**FFERM WYNT ALLTRAETH AWEL Y MÔR ARFAETHEDIG / PROPOSED AWEL Y MOR
OFFSHORE WINDFARM**

**CYFEIRNOD YR AROLYGIAETH GYNLLUNIO / PLANNING INSPECTORATE REFERENCE:
EN010112**

RE: NATURAL RESOURCES WALES' WRITTEN SUBMISSION FOR DEADLINE 3

ANNEX A

DRAWING TITLE
FIGURE 2: INDICATIVE HAUL ROAD
WATERCOURSE CROSSING - GENERAL
ARRANGEMENT - BAILEY BRIDGE

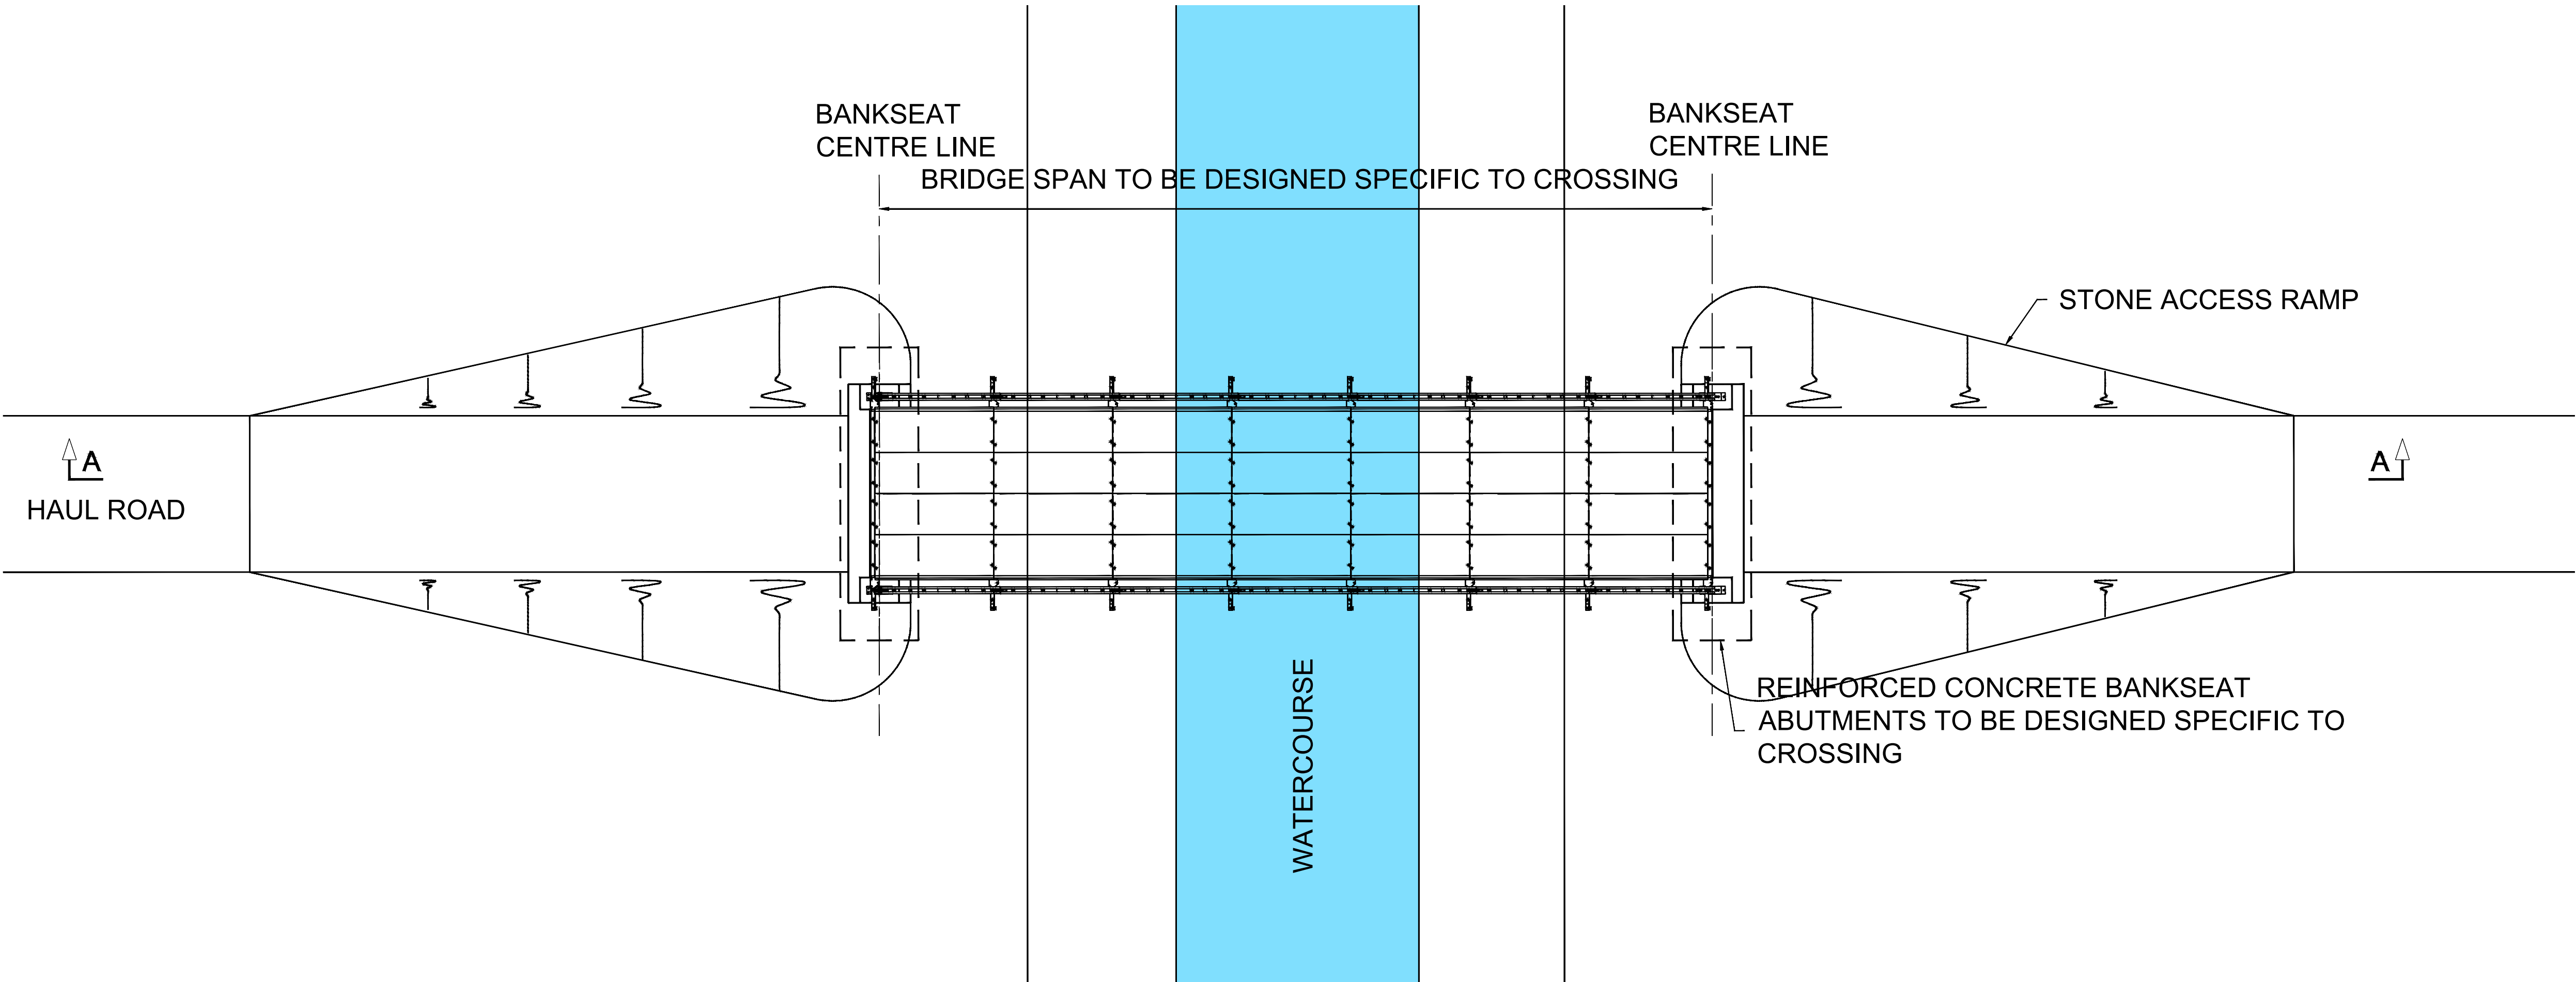
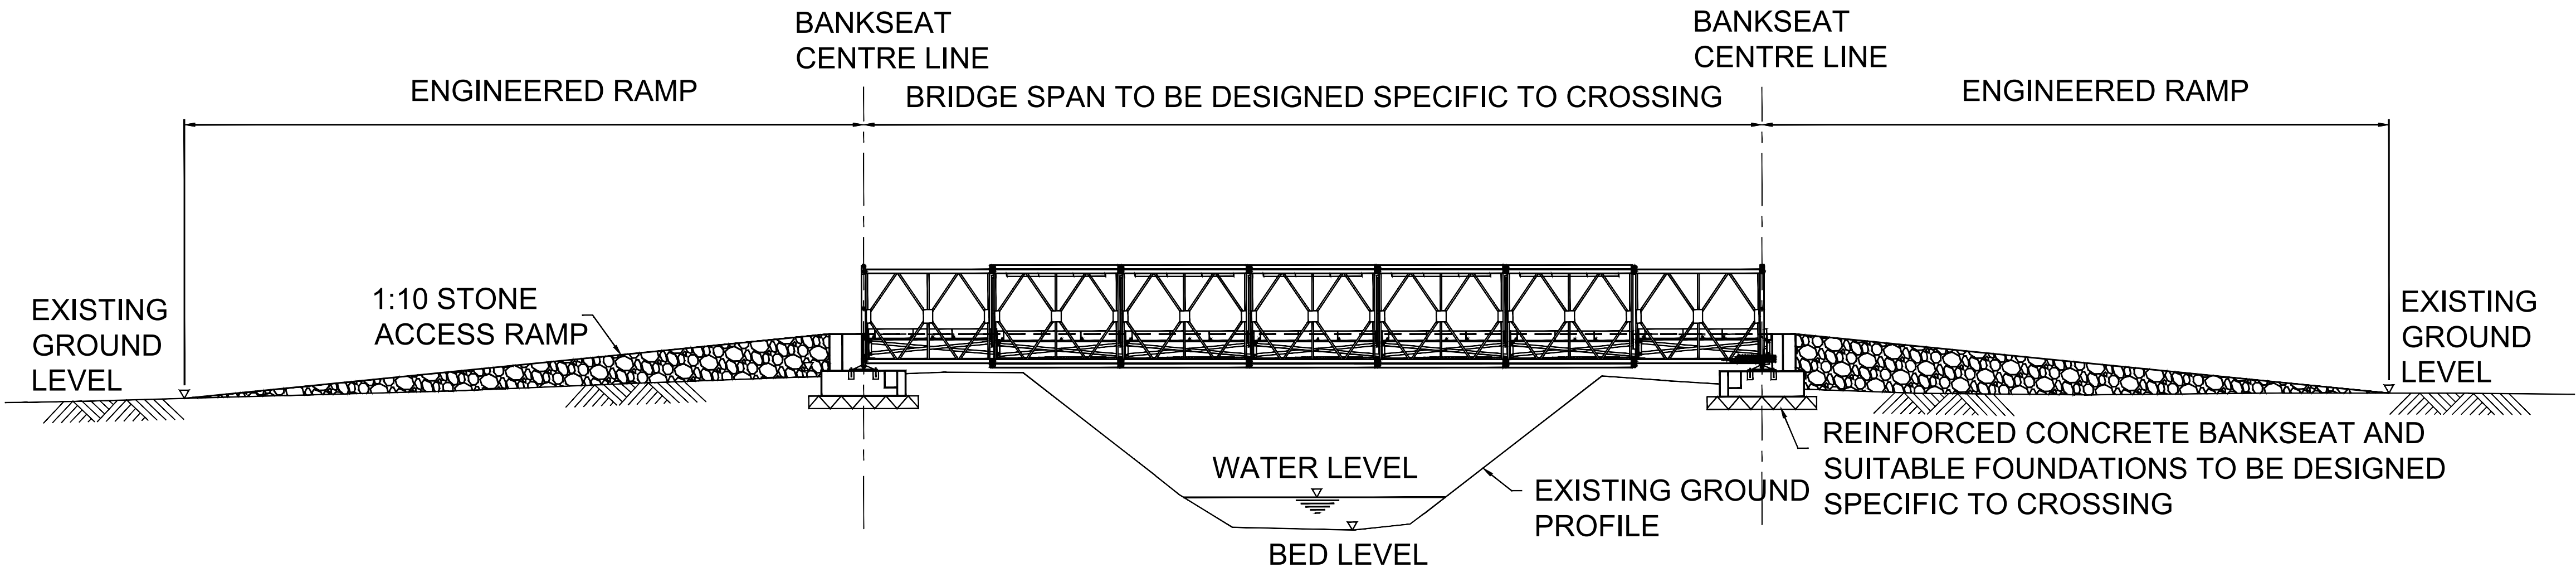
2.3.1. In paragraphs 3.6.2 and 3.6.3 of NRW's Deadline 1 submission, we advised amendments to the Outline Pollution Prevention and Emergency Incident Response (PPEIR) Management Plan [APP-318] and Outline Construction Method Statement (CMS) [APP-313]. We have reviewed the revised Outline CMS [REP2-017] and Outline PPEIR Management Plan [REP2-036] submitted at Deadline 2 and are satisfied that our previous comments have been addressed. As detailed in paragraph 2.2.2 above, a revised Draft Development Consent Order has also been submitted at Deadline 2 [REP2-014] which includes specific reference to NRW as a consultee for Requirement 10 (which requires the submission of a final CMS and PPEIR Management Plan). Based on the above, we are satisfied that potential impacts on water quality (both surface and groundwater) can be appropriately managed. We would however refer you to our comments with respect to WFD (paragraphs 3.3.1 – 3.3.7 (Annex A) of our Deadline 1 submission) which advises further information should be provided with respect to the watercourse crossing options retained at some locations.
